Comment from Greenspace

APPLICATION A/38/18/RES

Site Address: Manor Nursery High Street Angmering BN16
4AW

Description of Works: Approval of reserved matters following outline consent A/51/14/OUT relating to appearance, landscaping, layout & scale for demolition of the existing Manor Nursery Garden Centre & hard standing & redevelopment for 32No. dwellings with associated access, public open space & landscaping.

3.04 OUTLINE CONSENT

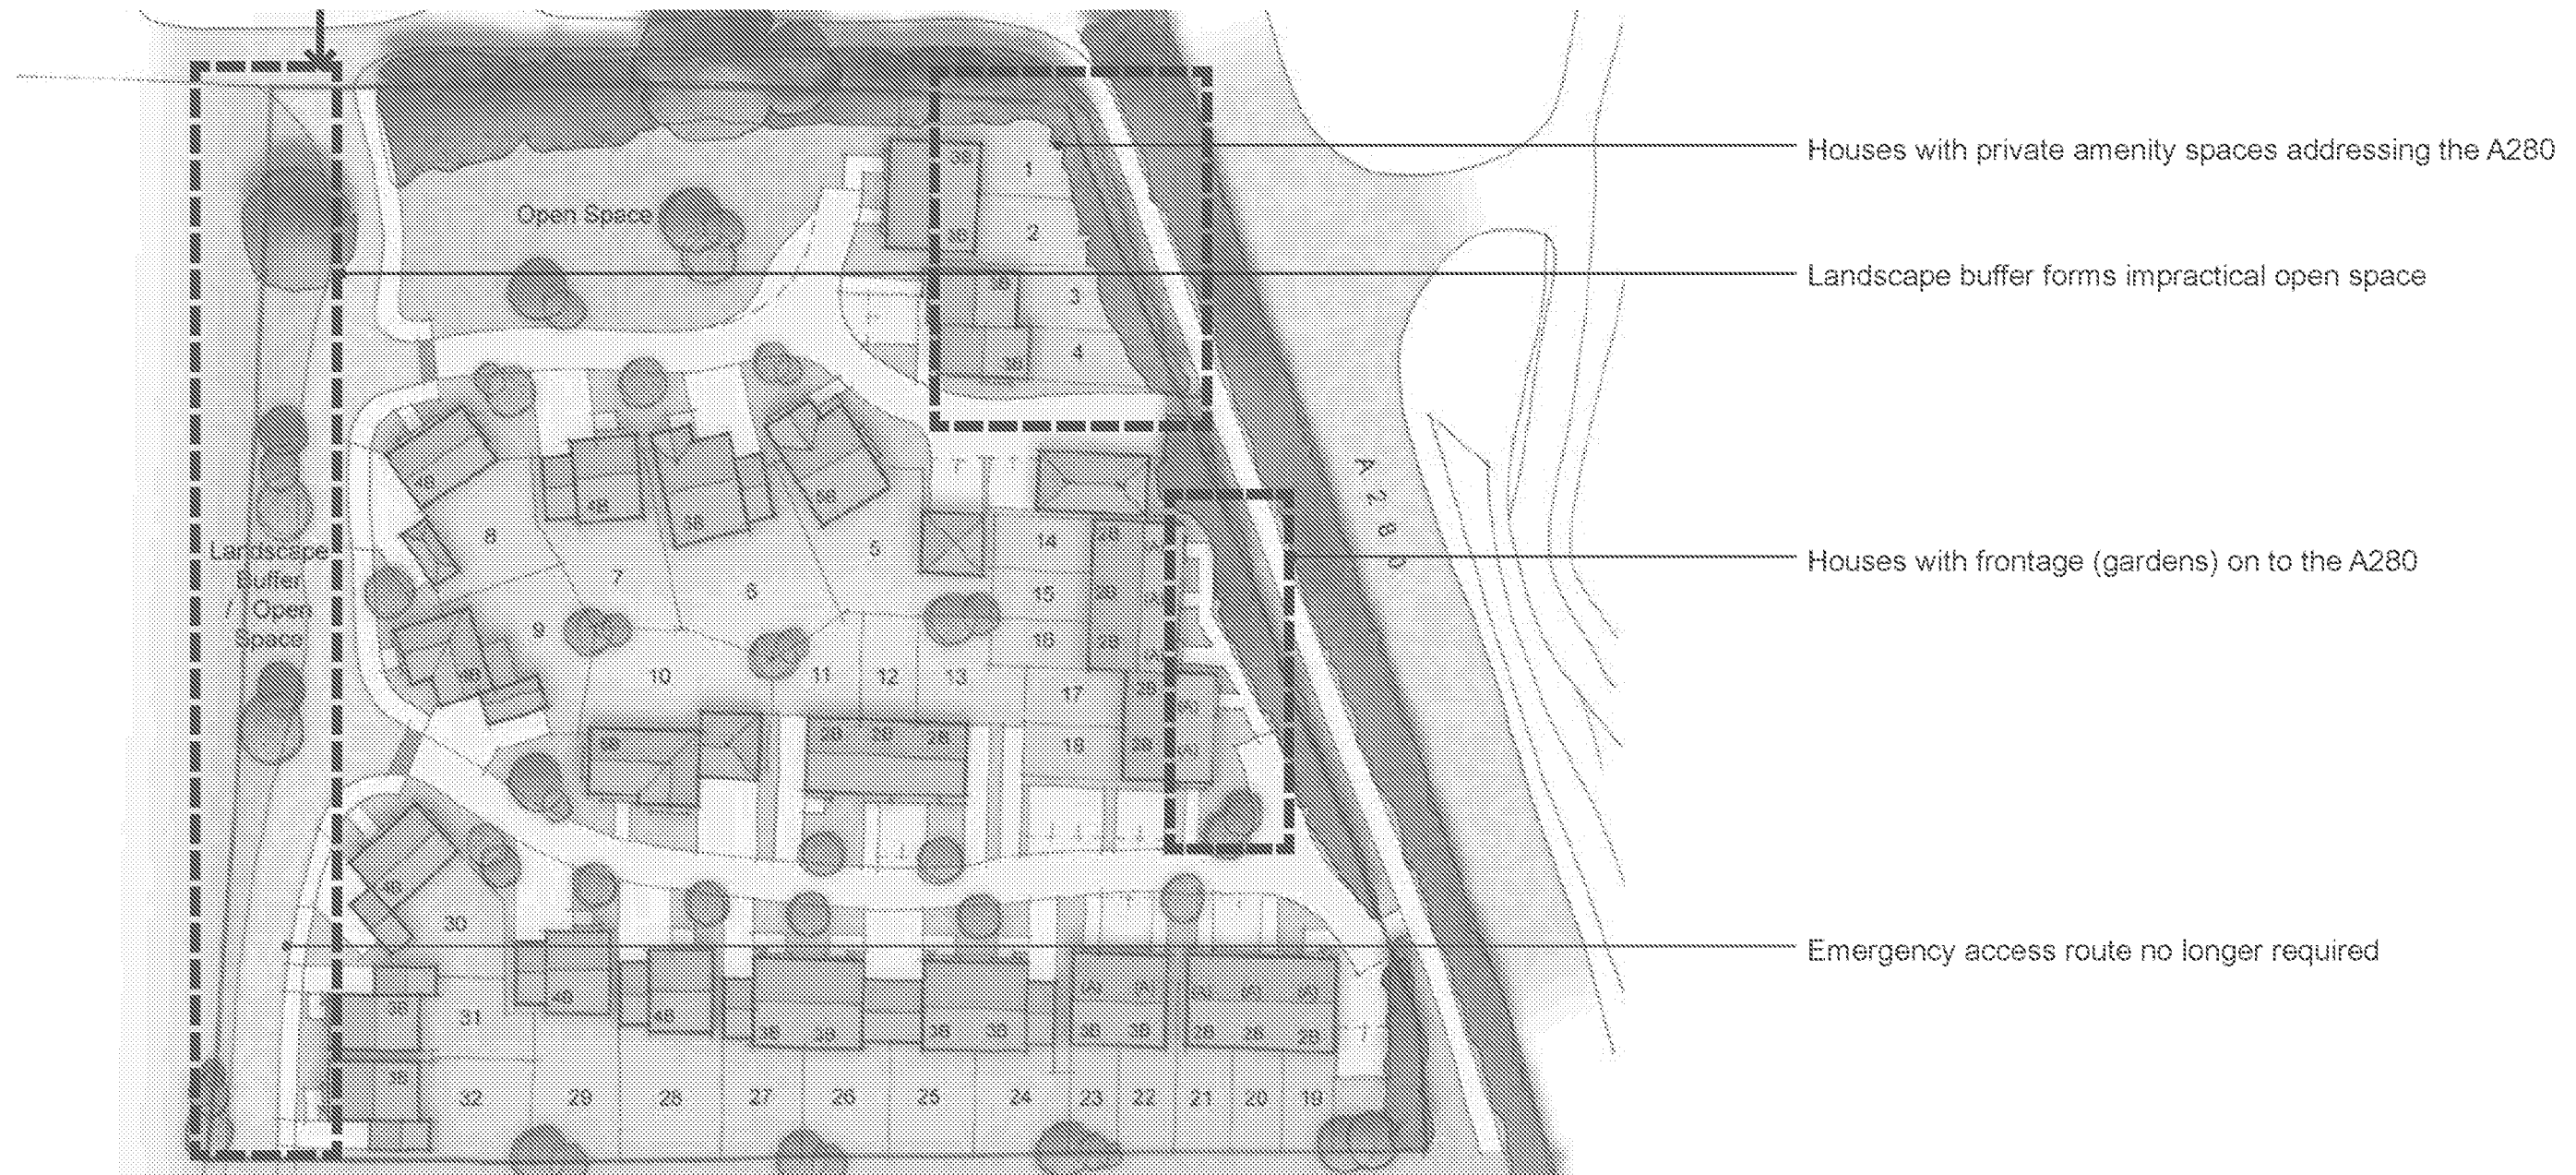
The illustrative site layout 13114/P101 indicated larger areas of POS within the development and also a larger band to the west of the site which appears to have been depleted within this application. Confirmation of the quantity of POS being provided within this application should be confirmed so that it can be assessed to that which was approved. The two areas of POS now shown as informal POS 91m2 and POS 307m2 are in my opinion not particularly usable open space areas and have no connectivity with the site or each other, it would be better to see these as one or two larger areas as the illustrative showed them to be.

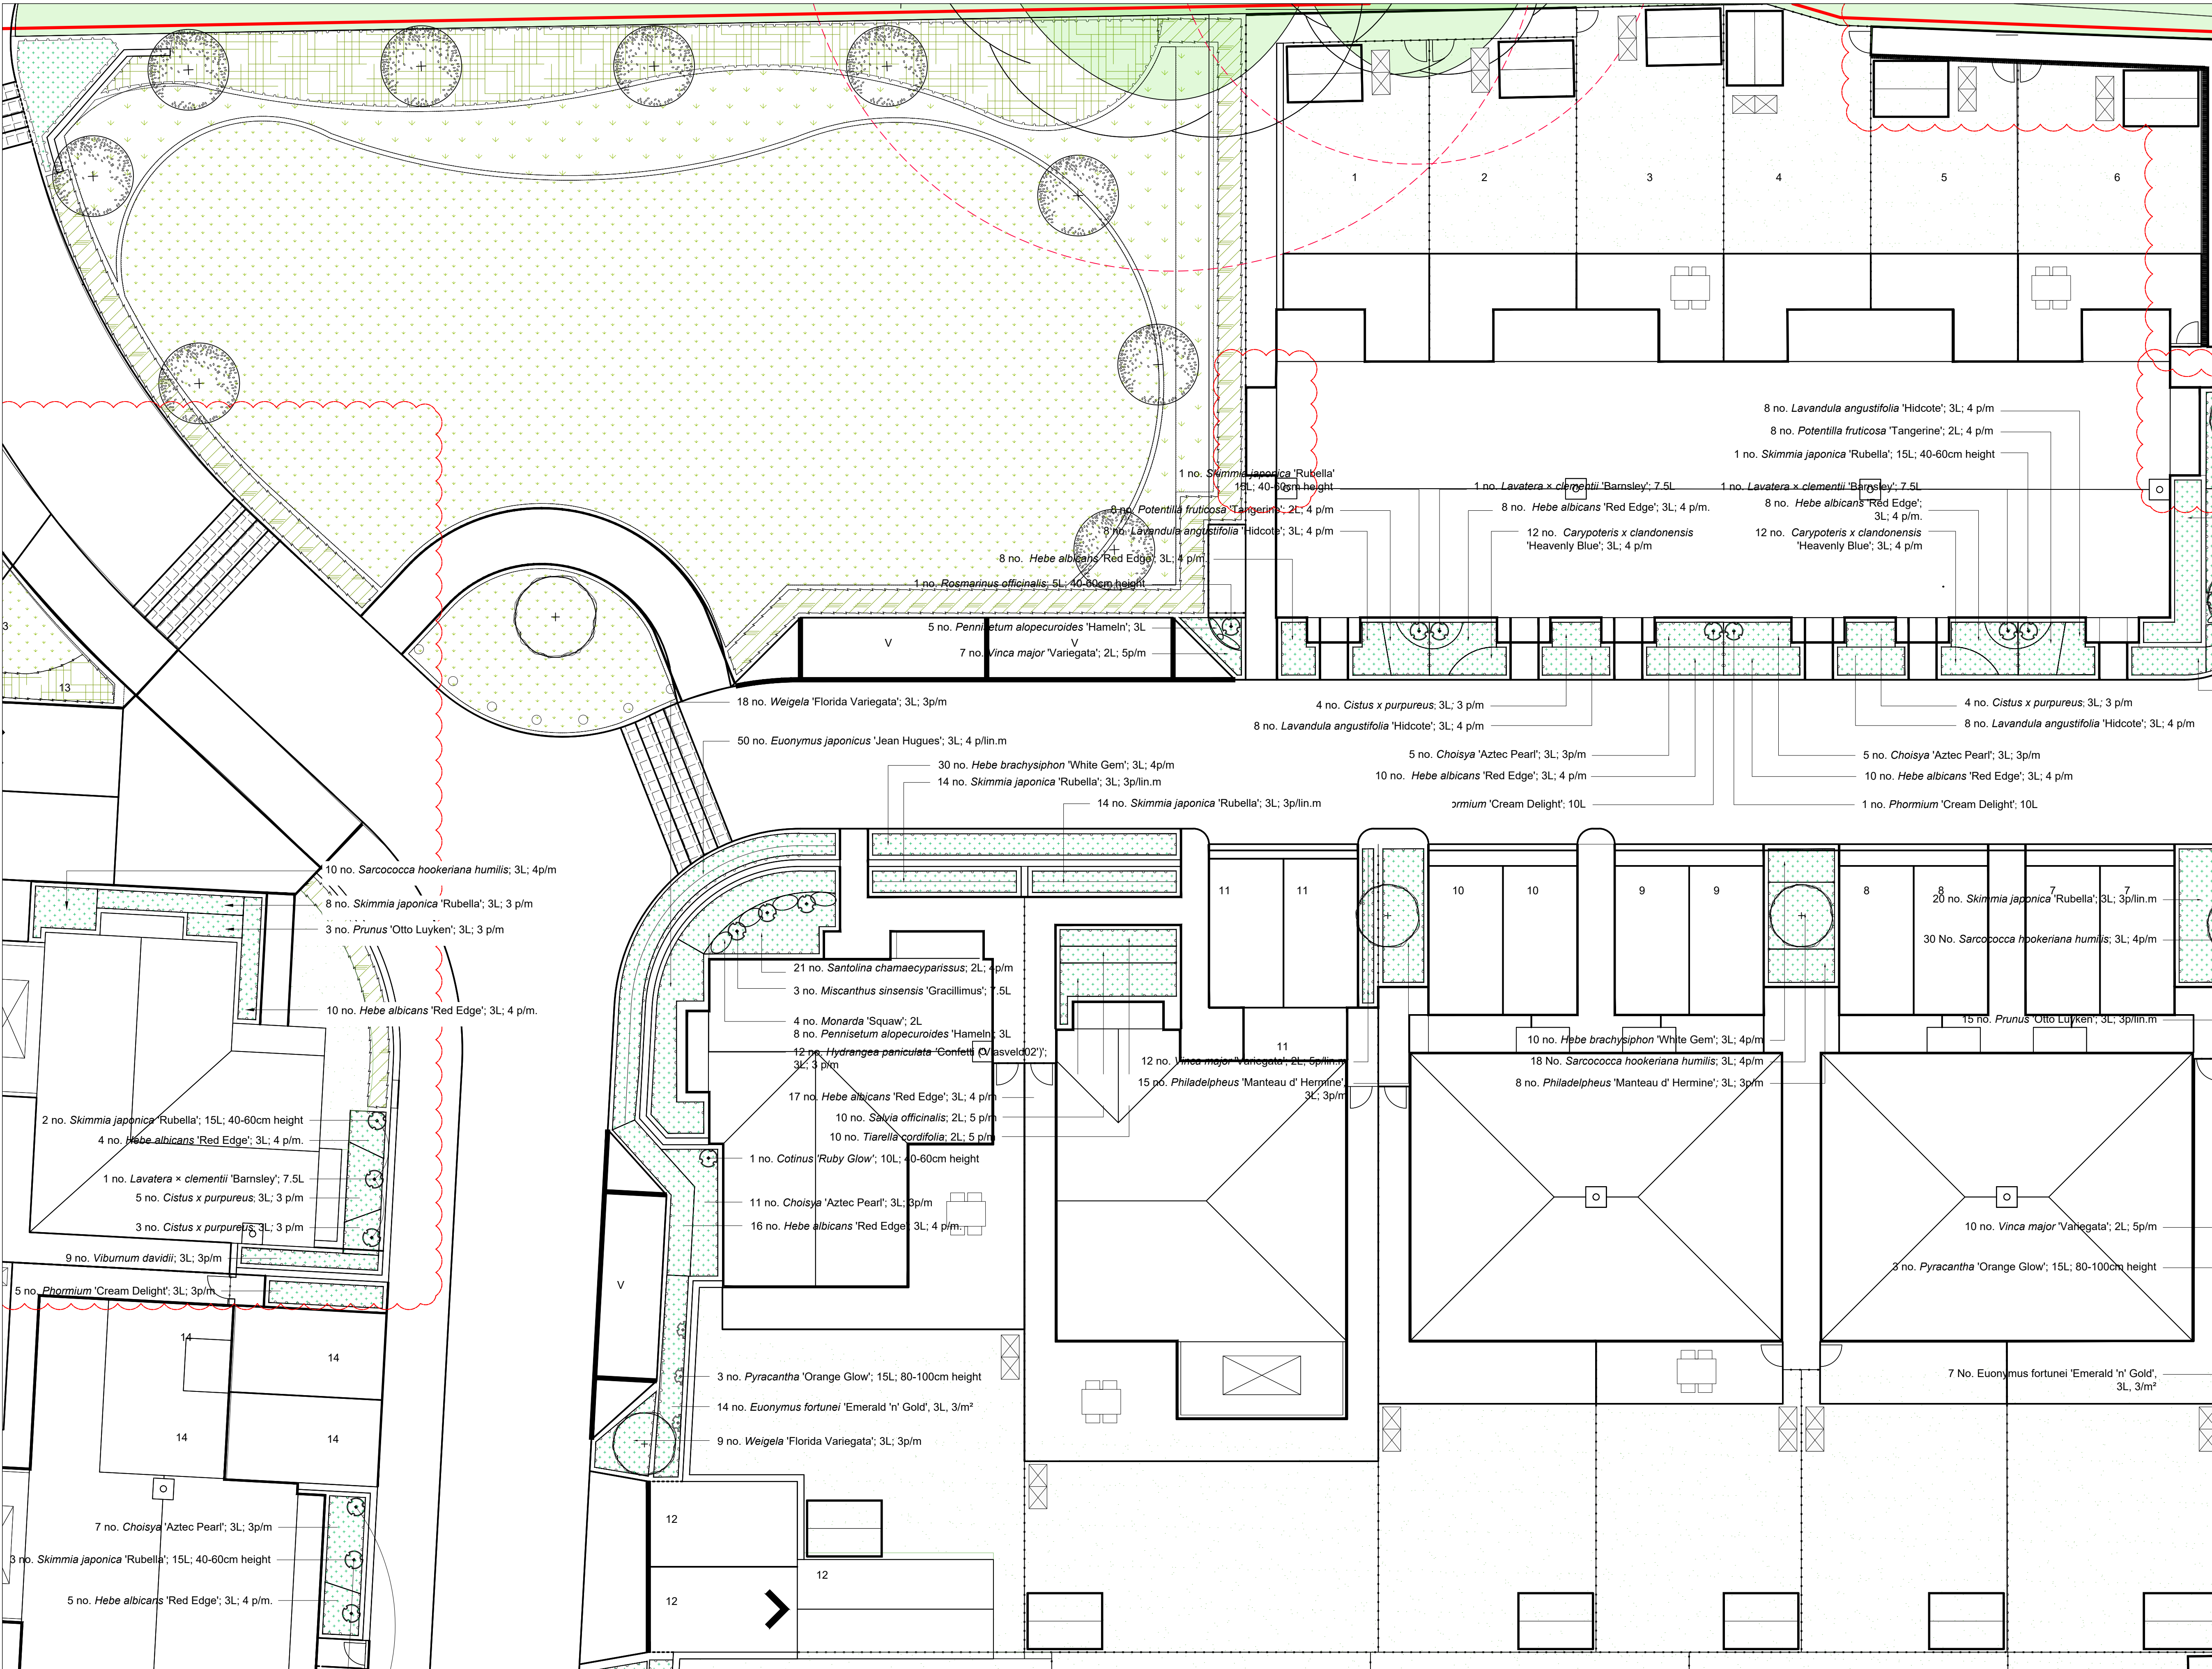
Having viewed this application and the submitted landscape detail I would comment that the details submitted under A/38/18/RES differs somewhat from those under the outline consent A/51/14/OUT.

I note from the Section 106 agreement from the outline consent that there was a requirement for .20ha of POS to be provided, this layout would appear to be providing only .12ha which is insufficient for the number of dwellings. The 106 agreement also made reference to a requirement for fitness trail equipment to be provided to the value of £16,242.00, please can confirmation be provided as to whether this is for onsite or offsite provision? If on-site where this is to be located within the proposals?
